DECISION DELEGATED TO HEAD OF PLANNING

Application No: H14-0678-26 **Applicant:** Mrs T Hull
Proposal: Proposed first floor extension and alterations
Location: 25 Orchard Close Pinchbeck Spalding
Terminal Date: 14th September 2026

J218-PL 1A

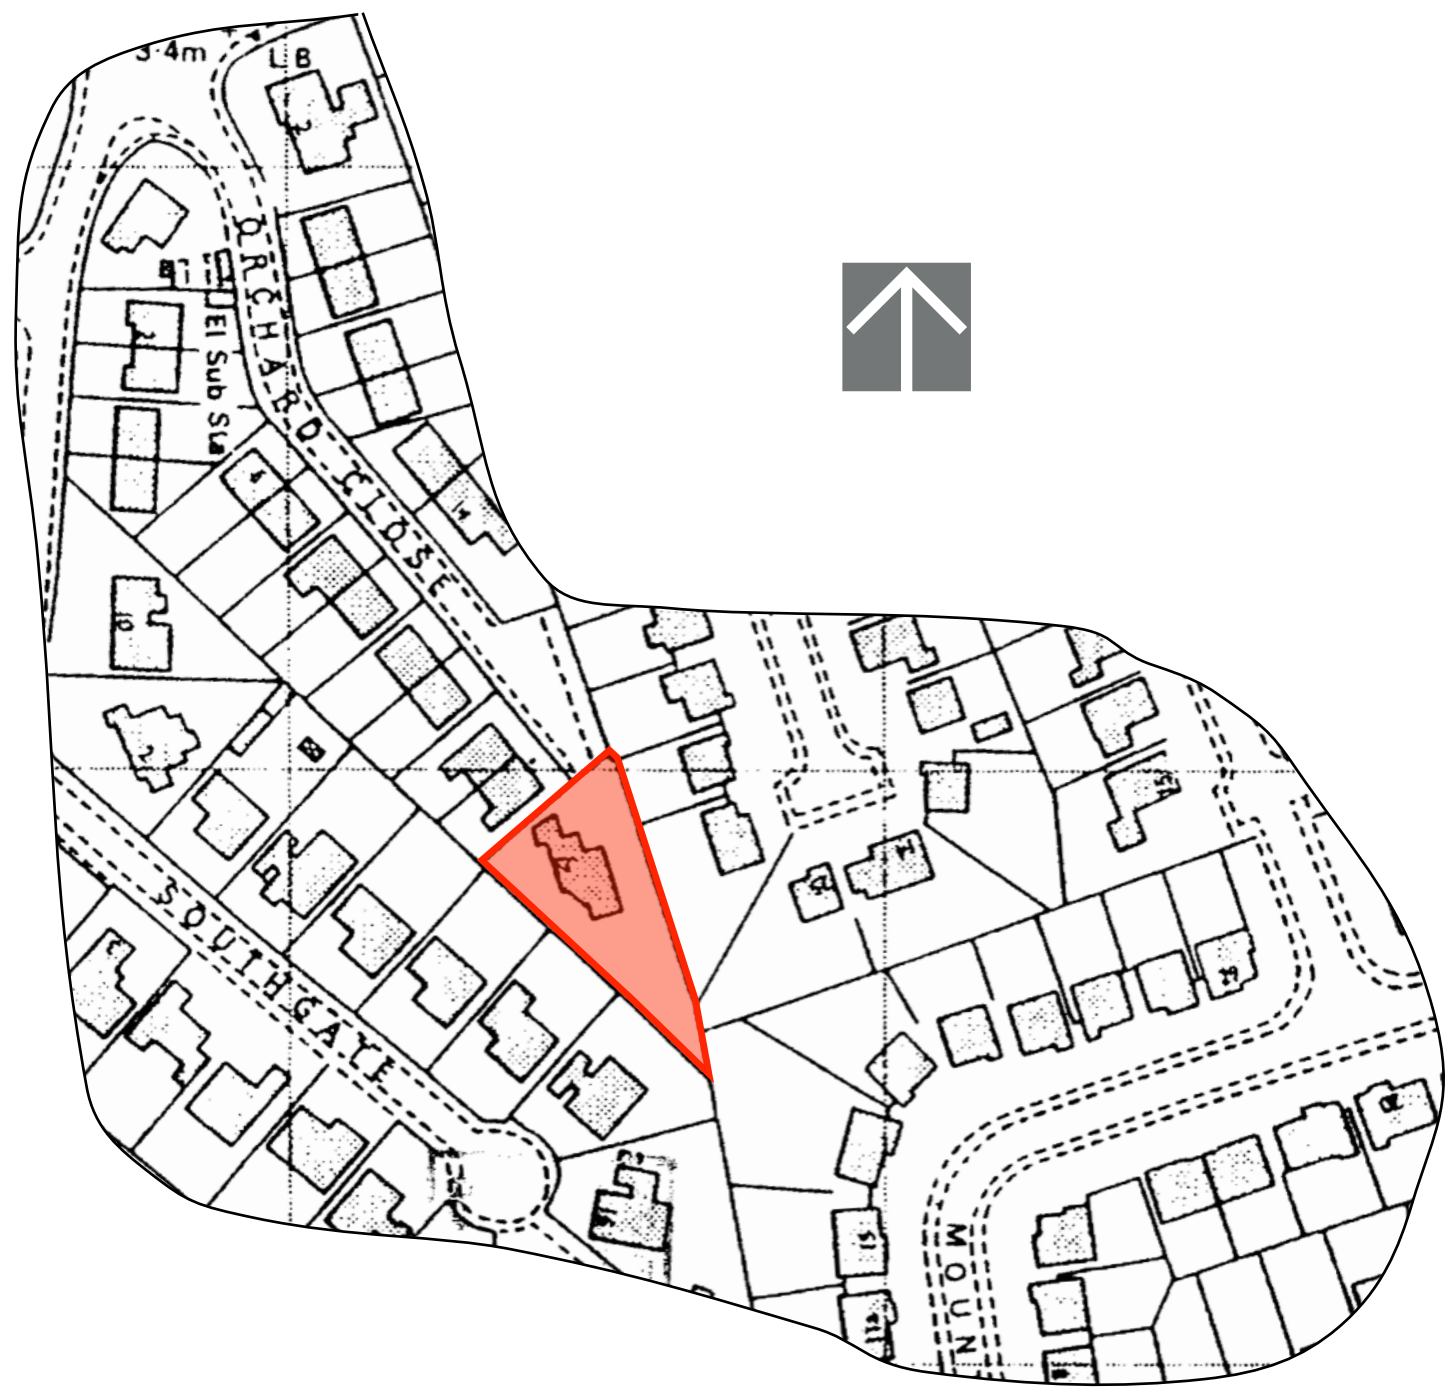
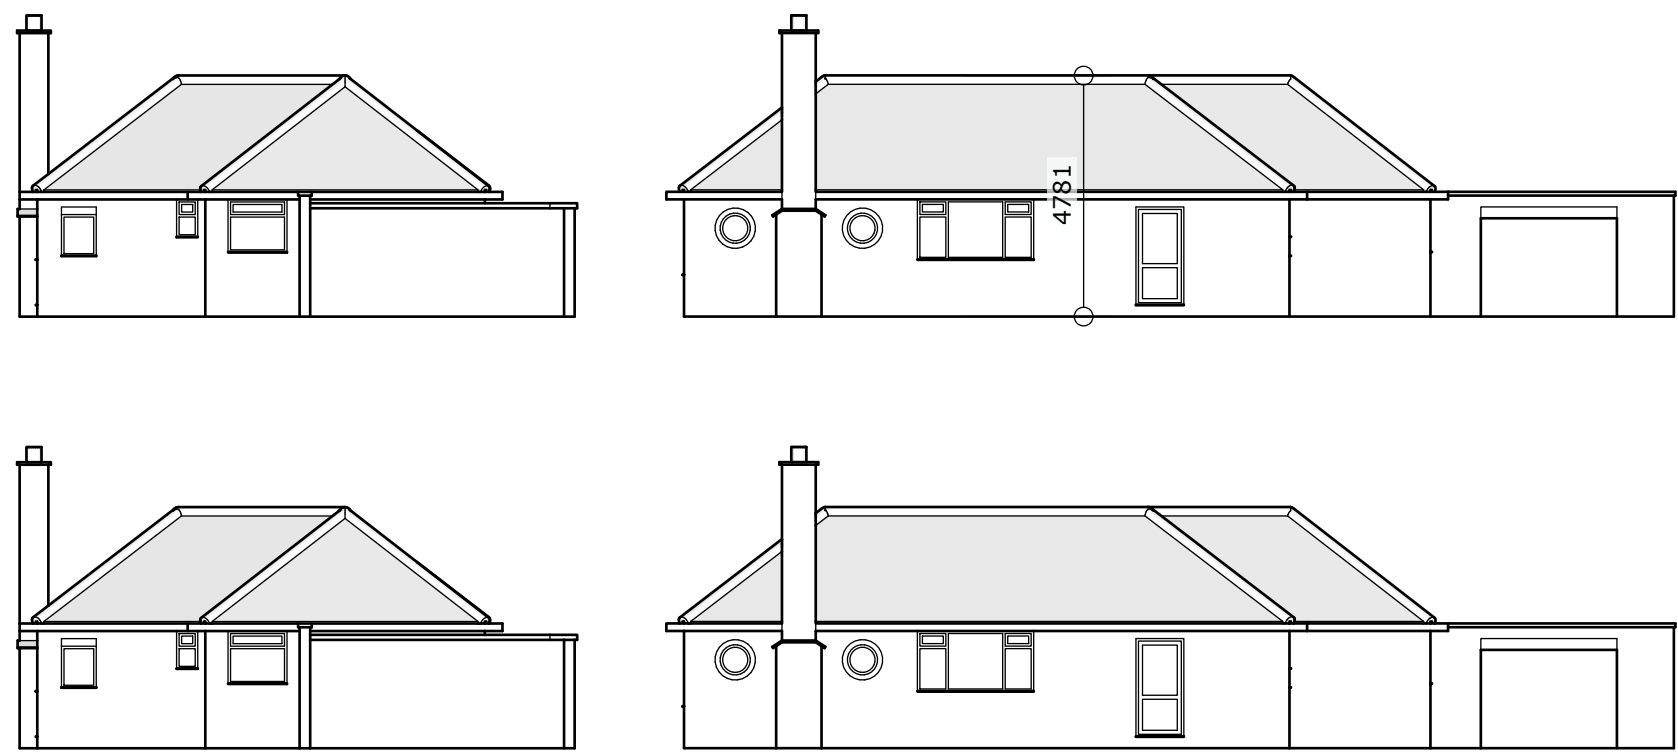
The existing bungalow has a height of roughly 4700mm and 2400mm to the eaves with a total floor space of around 130sqm. This is considered to be a relatively standard size for a residential bungalow such as this and is of modest scale and proportions.

The extension, by way of an introduction of a first floor, would increase the number of bedrooms on site from two to four and as such, additional parking arrangements would be required. The driveway to the front of the site is considered to have sufficient room to provide off street parking arrangements for at least three vehicles and would therefore be in accordance with Appendix 6.
